Lime Down Solar Park

**Planning Inspectorate Reference:
EN010168**

**Wiltshire Council Comments on Submissions
Received at Deadline 6 and Deadline 6B**

Deadline 7 (2 October 2026)

Drawing file: published-documents / EN010168-002452-6.2 ES Volume 2 Figure  3-4-1 to 3-4-2 Landscape and Ecology  Mitigation Plan (Rev 4) (1 of 4).pdf

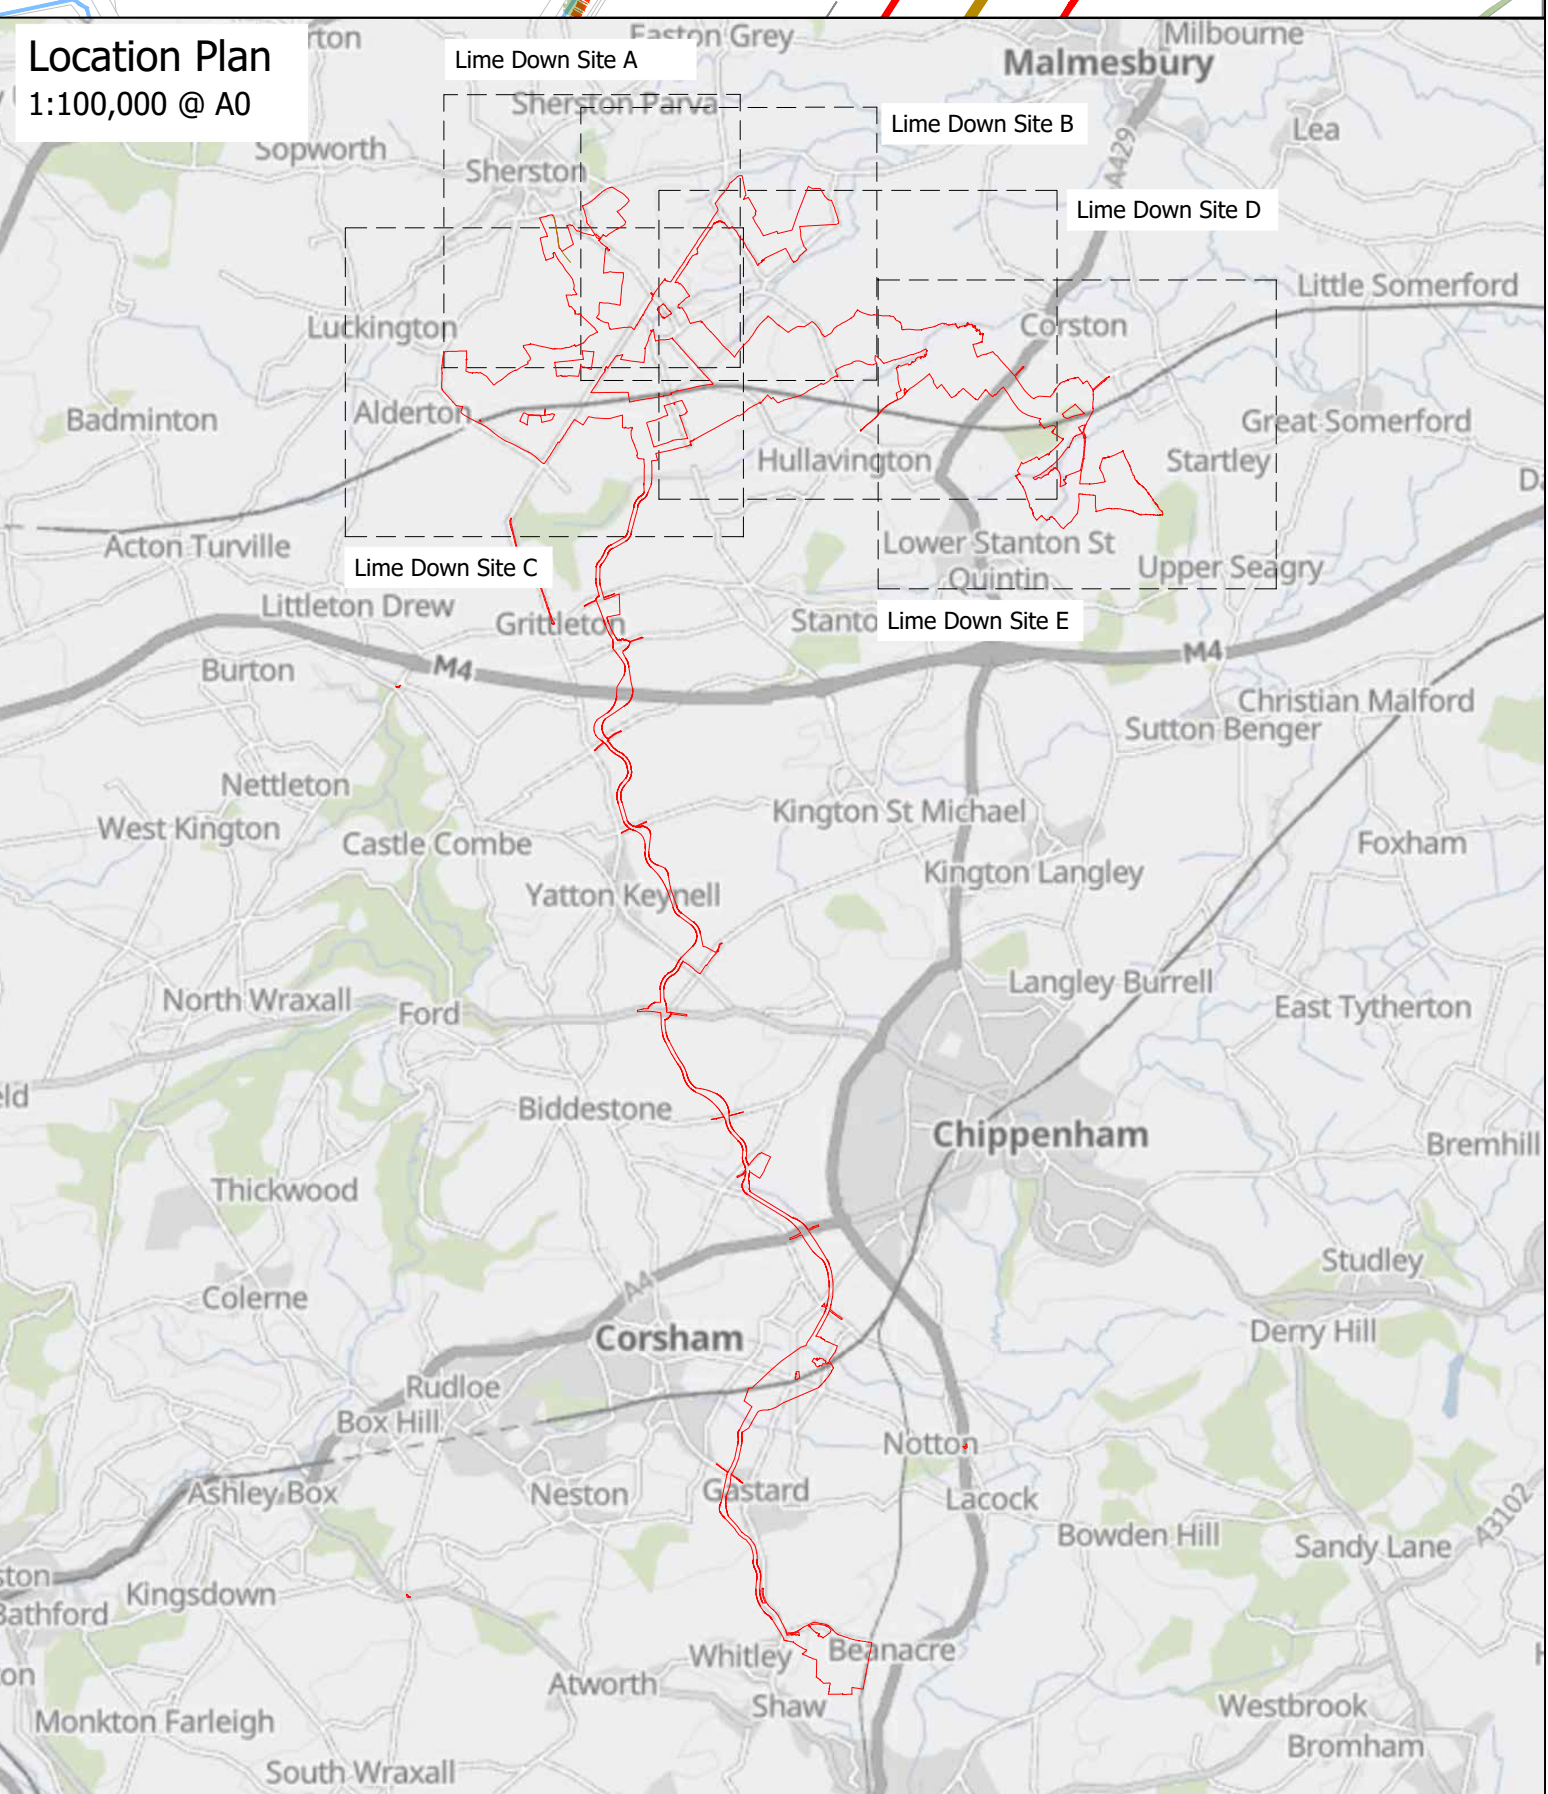
8. 6.2 Environmental Statement Volume 2 Figure 3-4-1 to 3-4-2 Landscape and Ecology Mitigation Plan (Rev 4) (1 of 4) [\[REP6-009\]](#)

- 8.1. The council has provided comments on submissions received at Deadline 5 [\[REP6-069\]](#) Paragraphs. 6.3 and 6.4, which included comments on [\[REP5-039\]](#) 6.2 ES, Vol 2, Figure 3-4-1 to 3-4-2 Landscape and Ecological Mitigation Plan (1 of 4) [\[Rev 3\]](#). These comments remain to be considered by the Applicant.

- 8.2. The council highlighted at Paragraphs. 6.3 and 6.4 [\[REP6-069\]](#) that:

6.3 'The council is unable to locate specific locations to understand the extent to which the applicant is proposing to restore dry-stone walls within the setting of the CNL on the submitted Landscape and Ecological Mitigation Plan for Lime Down A [\[REP5-039\]](#) (latest revision (4) [\[REP6-009\]](#)) despite it being referenced on the key. The council understands drystone walls are present along the eastern edge of field parcels A1 and A2, but they are not currently discernible. The Council believes the thin dashed brown line, is currently obscured by the thicker red line, denoting the order limit boundary. The Council considers it important to clearly identify where existing drystone walls are proposed to be restored on the 'Landscape and Ecology Mitigation Plan/s' [\[REP5-039\]](#) and revised to address this.'

- 8.3. And further that:

6.4 'The council additionally notes reference within the drawing key to 'existing drystone wall to be retained' within the 'Landscape and Ecological Mitigation Plan' for Lime Down A [\[REP5-039\]](#). The council suggests that the current wording on this drawing key should be changed to 'existing drystone wall to be retained and restored', alongside clearer visual identification on the plan to where these walls are located would provide greater planning certainty that the restoration of drystone walls will be delivered by the project and a clear link to Requirement 7 (Landscape and Ecological Management Plan) is secured.'

- 8.4. The council provided further comments on the Landscape and Ecology Mitigation Plans [\[REP5-039; REP5-040; REP5-041; REP5-042\]](#) at section 4 of

its comments on submissions received at Deadline 5 [\[REP6-069\]](#) pertaining to internal access tracks and roads, which also remain to be considered by the Applicant.

8.5. The council highlighted at section 4 that:

“The Council notes the alternative AIL road route through field parcels E2, E3 to reach the planned 132kV substation in field parcel E5 (Lime Down E) with the aim of avoiding impacts to Bincombe Wood (Ancient Woodland) from the original planned route. However, the Council observes that the original AIL route running along the northern edge of Bincombe Wood still remains on the Lime Down E Figures [\[REP5 042\]](#) in addition to the revised AIL track route around the northern and eastern edges of field parcel E3.

The Council considers that the ‘Landscape and Ecological Mitigation Plans’ [\[REP5-039; 040; 041; 042\]](#) should be revised to differentiate between the different internal access track / road functions, with different keyed line-type colours, as they are all currently the same light brown colour, so specific routes and the differences within illustrative construction details [\[REP5-066\]](#) are not clear on the plans. The Council suggests the following three types of internal access tracks could and should be separately keyed and illustrated on plans;

- *‘Internal tracks to provide AIL access to the proposed 132kV substations’ (surfaced with granular porous materials). (As illustrated within [\[REP5-066\]](#) ES, Vol 3, APP/6.3, Appendix 3-3, illustrative drawings).*
- *‘Internal tracks/roads to provide AIL access to the proposed 400kV substation and BESS area’ (surfaced with non-porous macadam materials) incorporating roadside ditch/es (As illustrated within [\[REP5-066\]](#) ES, Vol 3, APP/6.3, Appendix 3-3, illustrative drawings).*
- *‘Internal access tracks within solar panel fields’ (surfaced with granular porous materials) which should be incorporated into [\[REP5-066\]](#) as an additional illustrative drawing*;*

**The Council suggests that if the illustrative construction details for ‘Internal access tracks within the Solar Panel fields’ is unlikely to differ from the illustrative construction details for the ‘AIL Internal Access Road Cross-Sections for 132kV Substations’, then the drawing could simply be re-titled ‘Internal tracks to provide AIL access to the proposed 132kV substations & Solar Panel fields,’ then only two types of access track would require to be included on the plans.”*

8.6. Furthermore, it is noted that the Deadline 6 Cover Letter [\[REP6-001\]](#) states that the figure has been updated to reflect the removal of panels and associated infrastructure from the southern part of Field A1 and that this has been replaced with proposed wildflower meadow. It specifies that this has also resulted in a small shift of the panels in Field A2 further to the south to accommodate a new hedgerow between Field A1 and A2, and the associated buffer requirements between the A2 panels and that hedgerow.
